WEST SUSSEX COUNTY COUNCIL CONSULTATION

TO:	Arun District Council FAO: Amber Willard
FROM:	WSSC – Highway Authority
DATE:	18 March 2026
LOCATION:	Land East Of The Croft Surgery Barnham Road Eastergate PO20 3RP
SUBJECT:	BN/10/26/PL Approval of details reserved by condition under BN/38/24/PL relating to conditions 5, 7, 16, 19, 20, 21, 22, 23 & 24. (See Application BN/12/26/DOC for conditions 8 & 9 - drainage). Additional plans received.
DATE OF SITE VISIT:	n/a (desktop study undertaken for purposes of this planning application)
RECOMMENDATION:	Advice

This is the **second** WSSC Highways response to the above planning application seeking approval of details reserved by condition under BN/38/24/PL relating to conditions 5, 7, 16, 19, 20, 21, 22, 23 & 24.

Comments below specifically respond to highways-related condition 16 (secure and covered cycle parking).

EXTERNAL WORKS Sht3

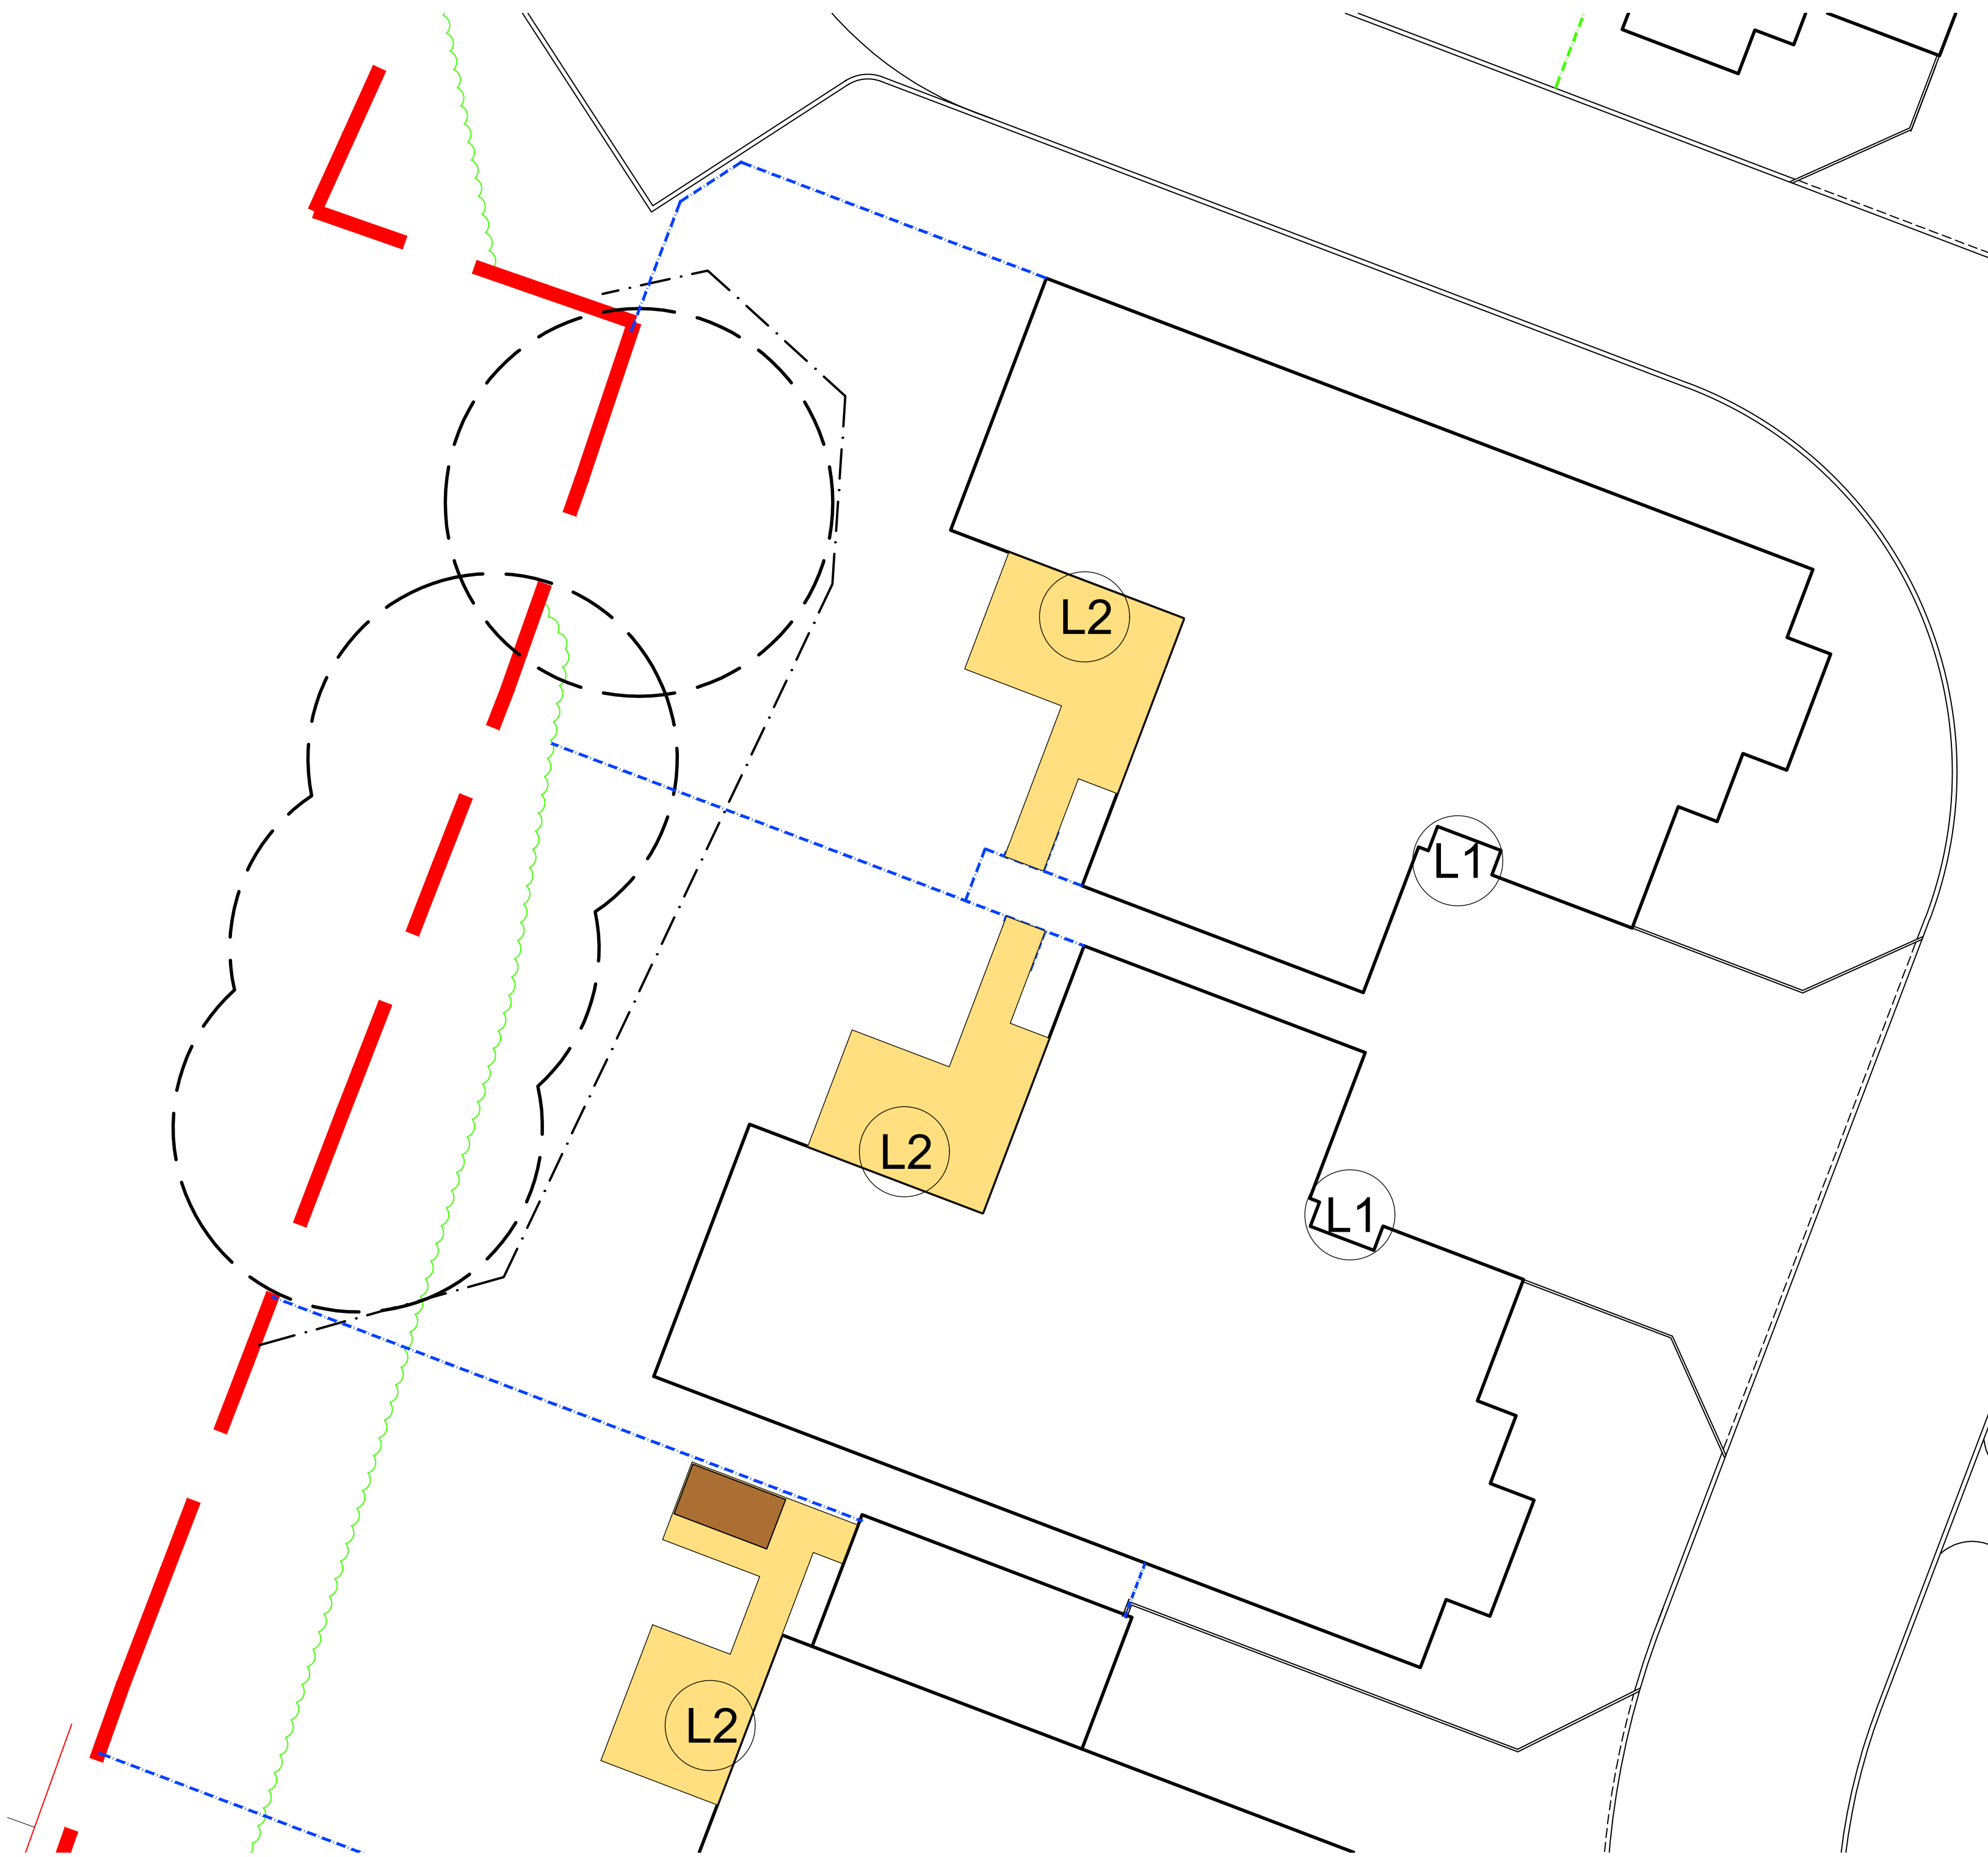
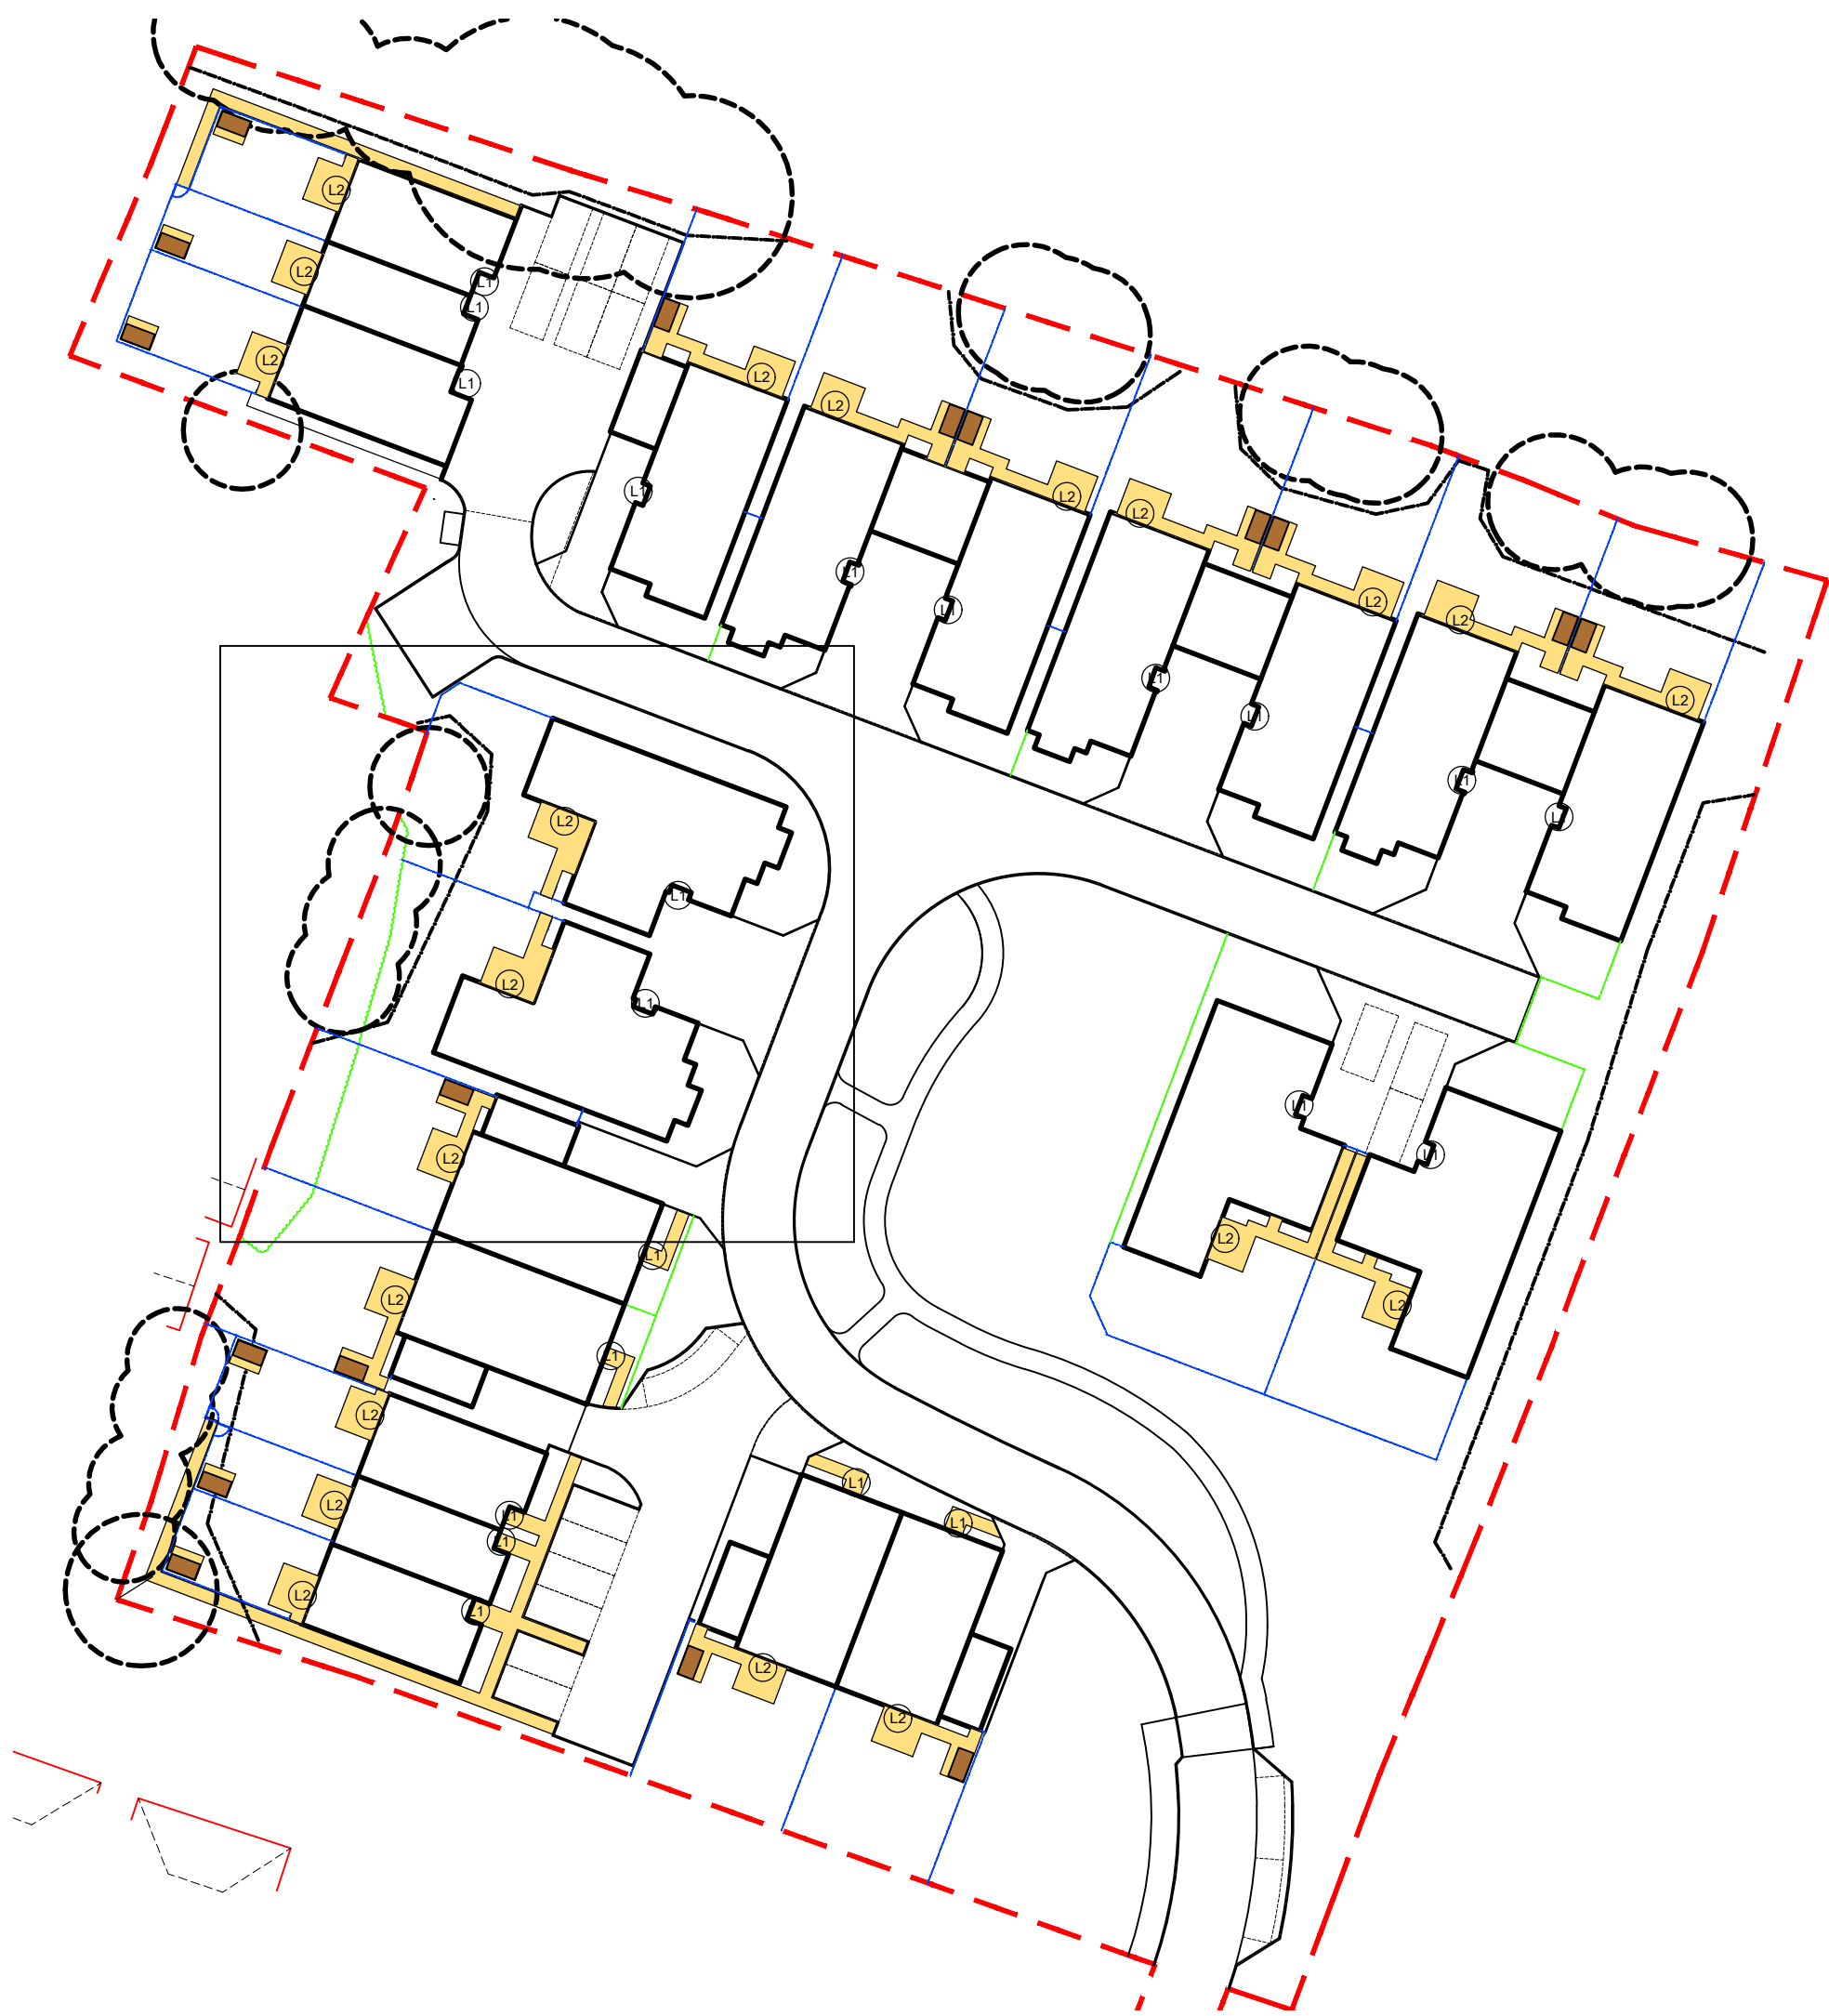
- (1)** The following extracts, taken from the external works plans, show the plots where it is not clear how access to the bicycle storage will be achieved from the access road. Applicant to provide details, please.

(2) And for the following (overleaf), no cycle storage is shown. Applicant to amend, please.

Drawing Number 2645-TFC-XX-00-DR-L-1001, revision P02, produced by Terrafirma Landscape Architects, now shows how cycle storage for each dwelling will be accessed.

This is also now shown (within garages) on Drawing Number 2645-TFC-XX-00-DR-L-1001, revision P02, produced by Terrafirma Landscape Architects.
